**Planning Application No: 3/2024/0149**

**Proposal: Proposed demolition of boundary wall and creation of new vehicular access and driveway.**

**Location: 4 Shaw Terrace Main Street Grindleton BB7 4RA**

6947 -P01

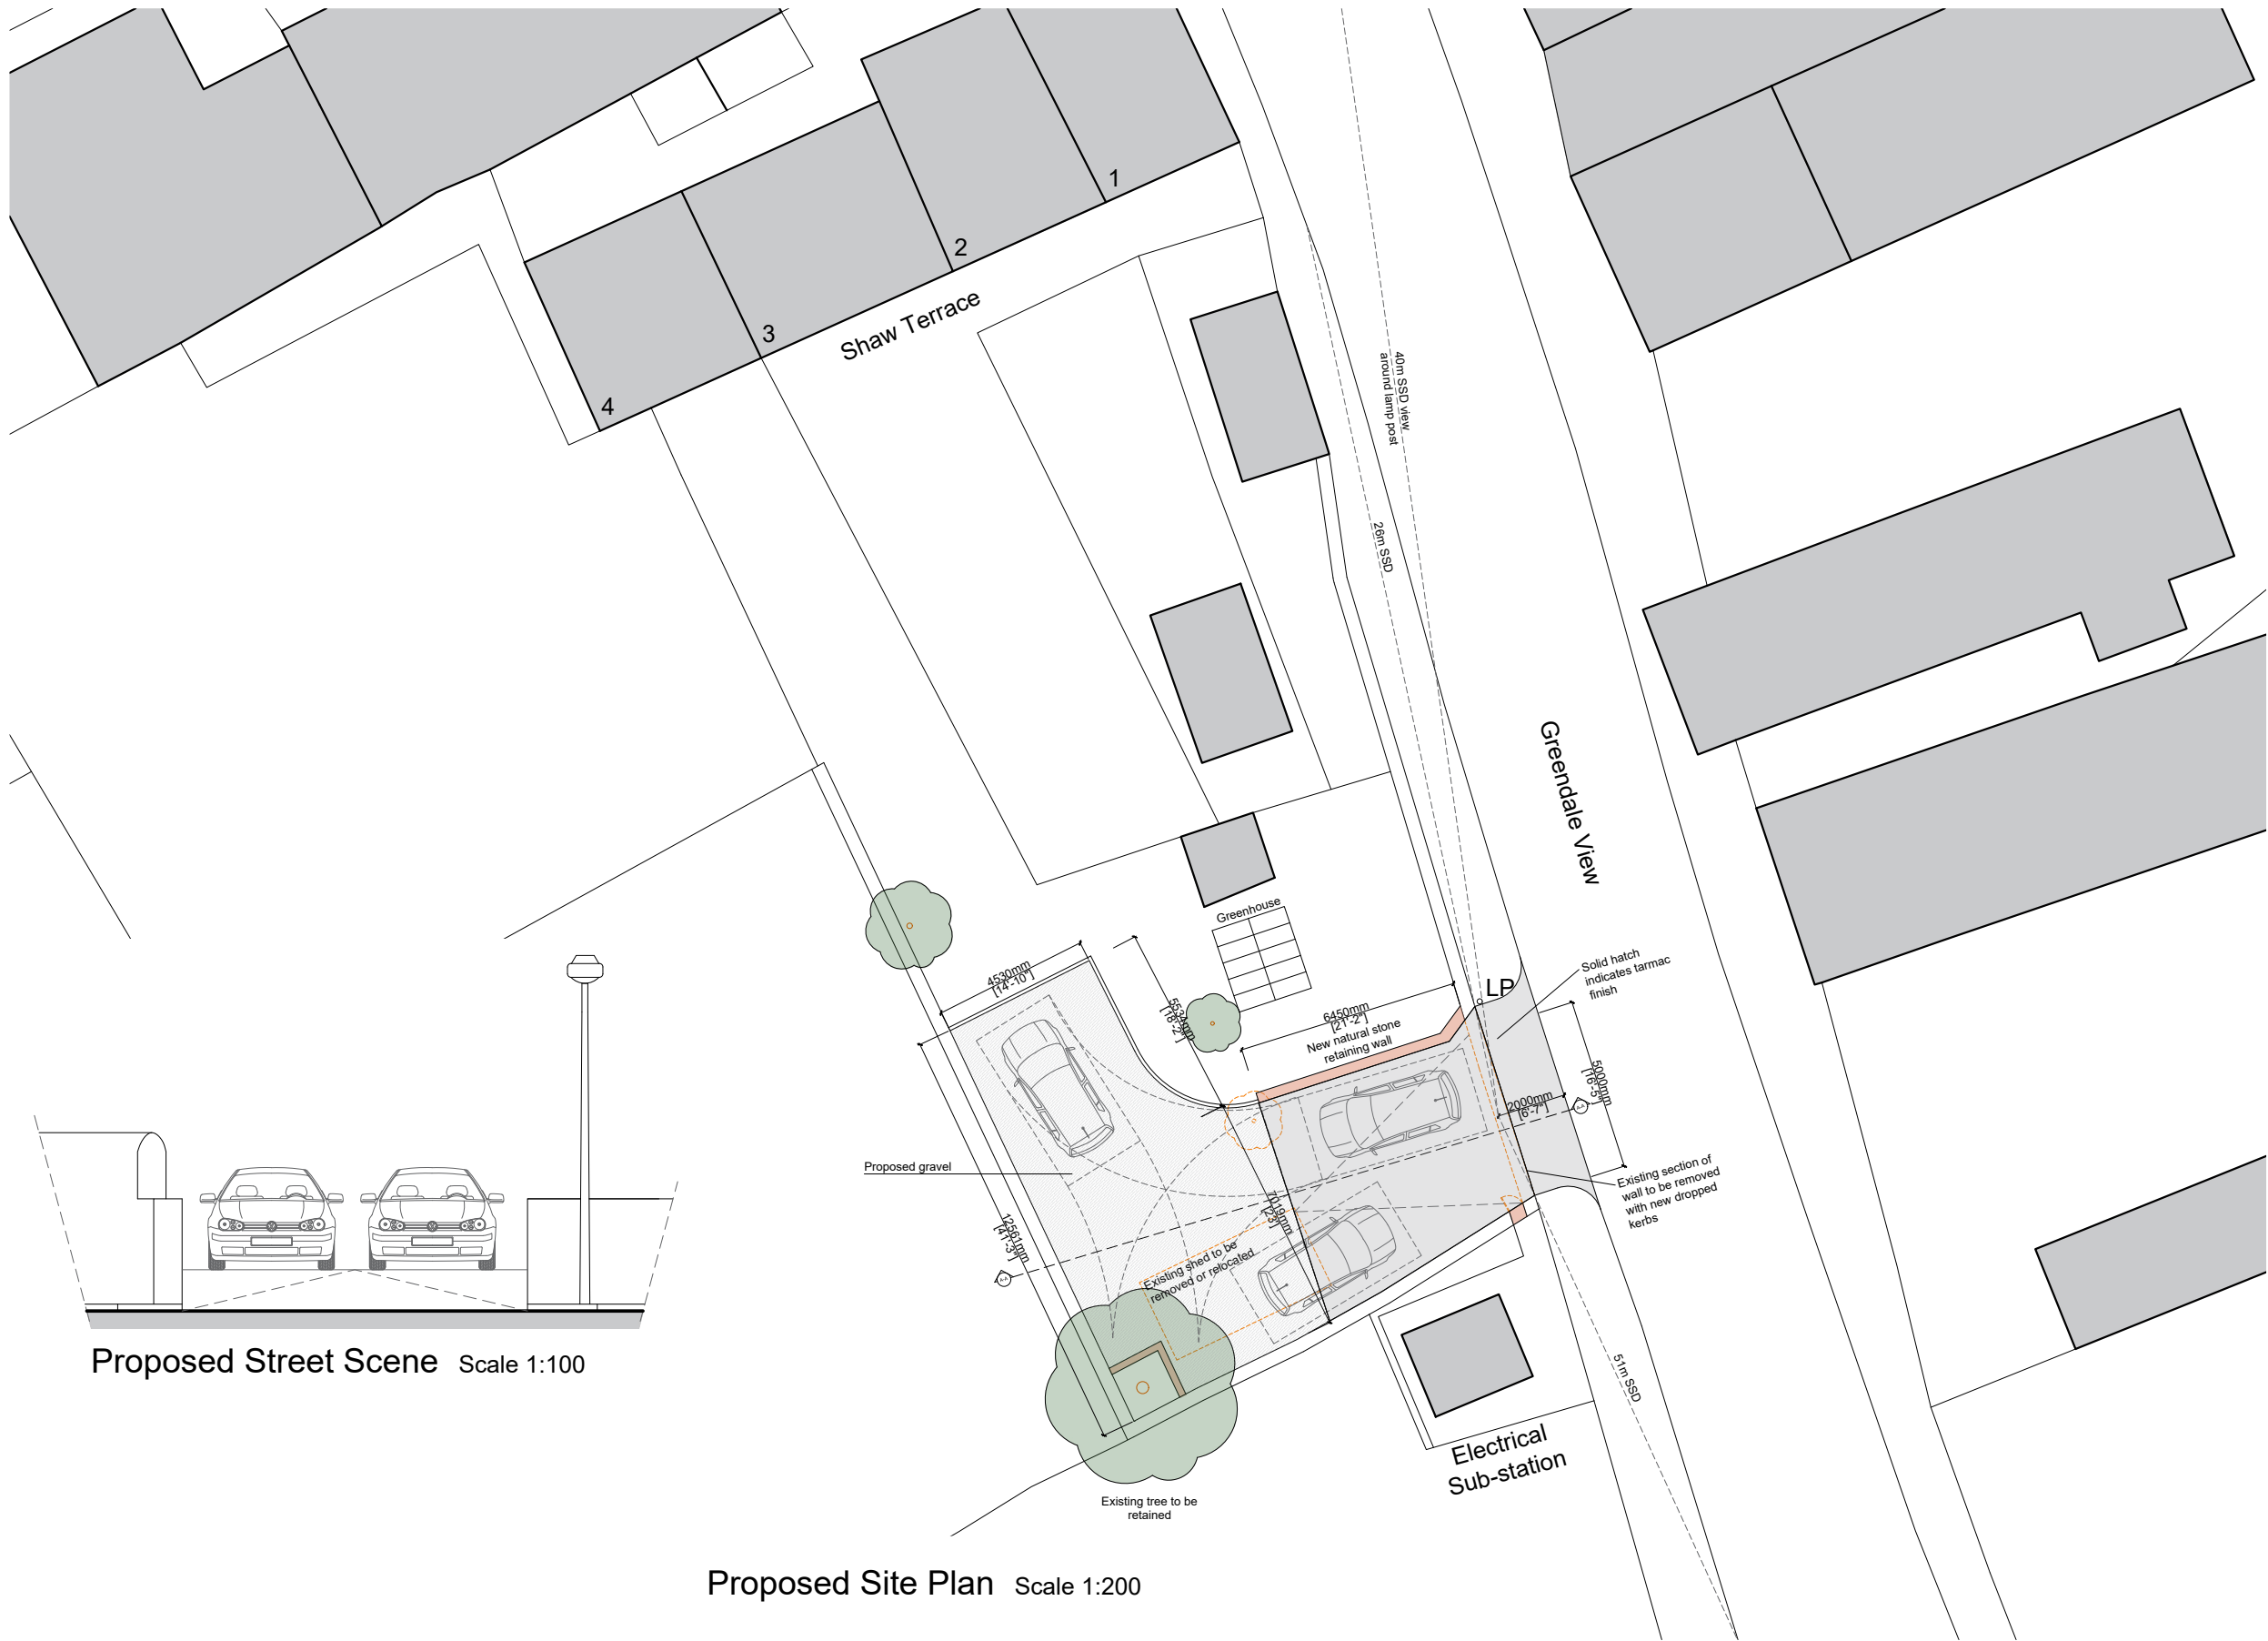
With reference to drawing no. 6947-P01 Proposed site plan, section and street scene submitted, this is acceptable.

The first 5m of the driveway from the rear of the footway into the site should be surfaced in a bound porous material. This is to prevent loose surface material from being carried onto the surrounding highway network, where it could pose a hazard to other users.

In addition, a means of collecting surface water from the driveway should be provided across the access, which should drain to an internal outfall. This is to prevent water from discharging onto the publicly maintained highway network. Details of the means of drainage can either be submitted as part of the planning application or we would request a condition to control it if planning approval is granted.
